From: Hannah Riddle on behalf of Planning.Responses
Sent: 16 February 2022 11:15
To: Planning Scanning
Subject: FW: Planning consultation - BR/283/21/PD Land to the rear of 27 Station Road Bognor Regis PO21 1QD

From: Ian Stocks [REDACTED] On Behalf Of FRS Water and Access
Sent: 16 February 2022 10:46
To: Planning.Responses [REDACTED]
Subject: Planning consultation - BR/283/21/PD Land to the rear of 27 Station Road Bognor Regis PO21 1QD

LOCATION PLAN

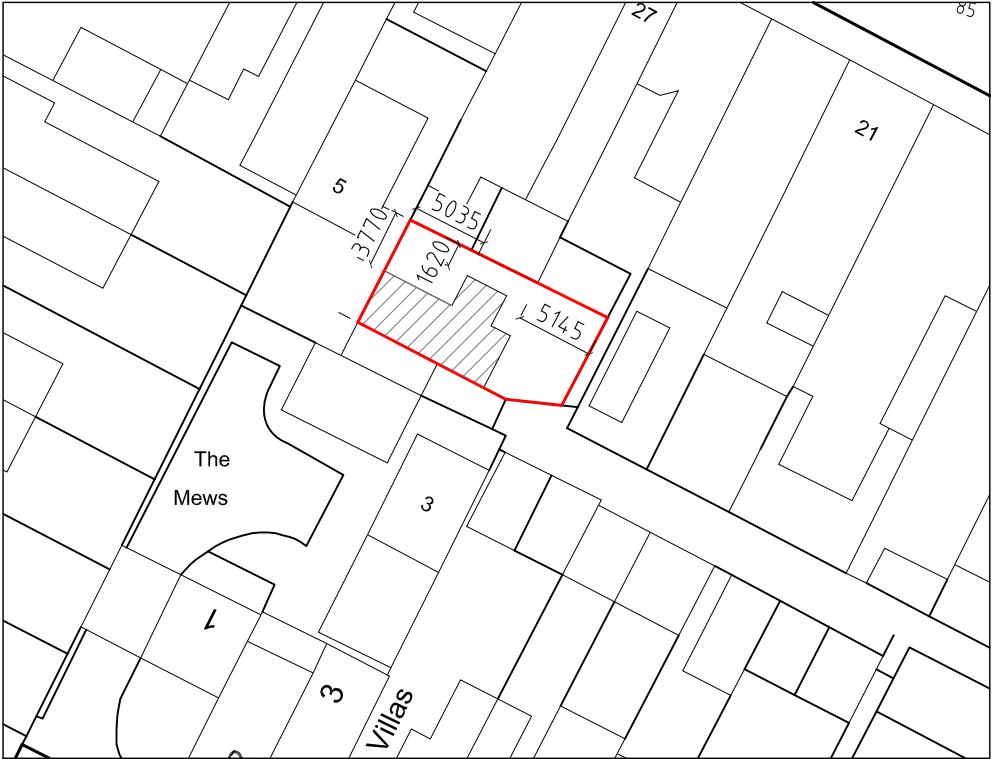
Having viewed the plans for planning application BR/283/21/PD, the access appears to show insufficient width for a fire appliance to gain access the new property, we need clarification that all parts inside the dwelling are within 45m as identified in Approved Document – B (AD-B) Volume 1 2019 edition: B5 section 13. Evidence will need to be provided to show sufficient turning facilities are provided for a fire appliance to turn and make their exit as identified in AD-b Vol 1 B5 section 13. This is particularly important due to the narrow access route and gateway for the access egress route form these premises.

Any areas outside the 45m rule will need to be mitigated by the installation of domestic sprinkler or water mist system conforming with BS9251 or BS8458 standards
